Lot 51
 Plan 2
 Parcel: 3414204005
 Elevation: Farmhouse
 Crawl Space
 Master Plan#: M153729
 Model: M1002

PLOT PLAN

466 INDIAN GRASS ST. CALHAN, CO 80808
 MAYBERRY, COLORADO SPRINGS FILING NO. 1
 A PORTION OF SECTION 14 & 15, T 14S, R 63 W, 6TH PM
 COLORADO SPRINGS, EL PASO COUNTY, COLORADO

DISAPPROVED
Plan Review

PLOT PLAN

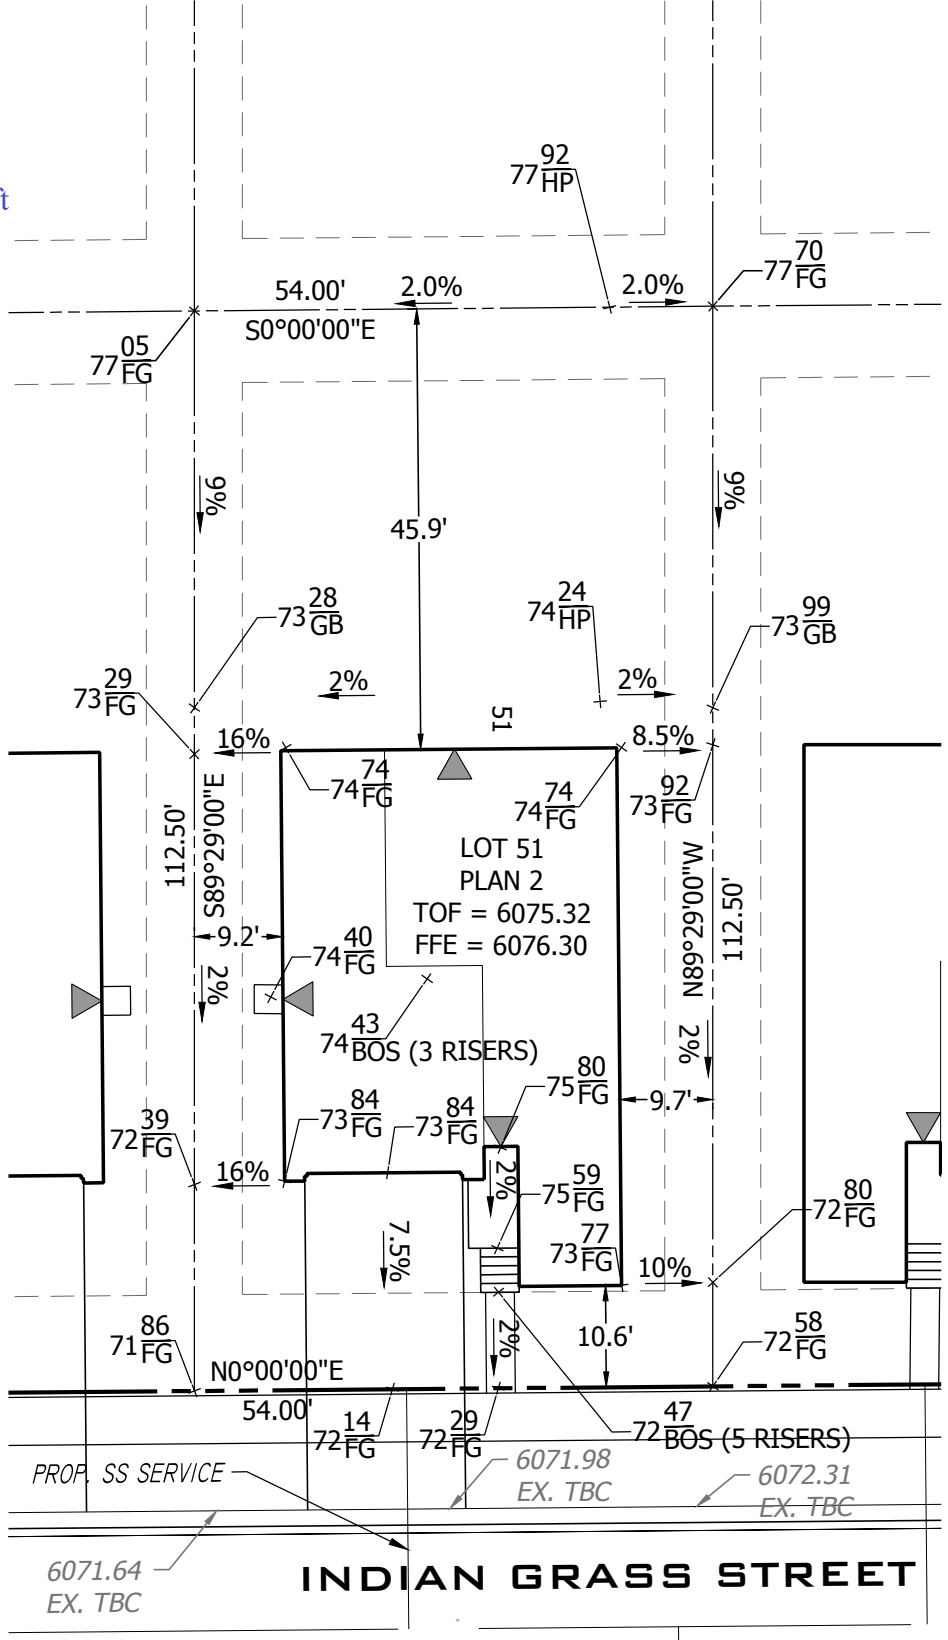
Provide site data (lot size,
 residence size, % lot
 coverage and average
 building height) on all site
 plans.
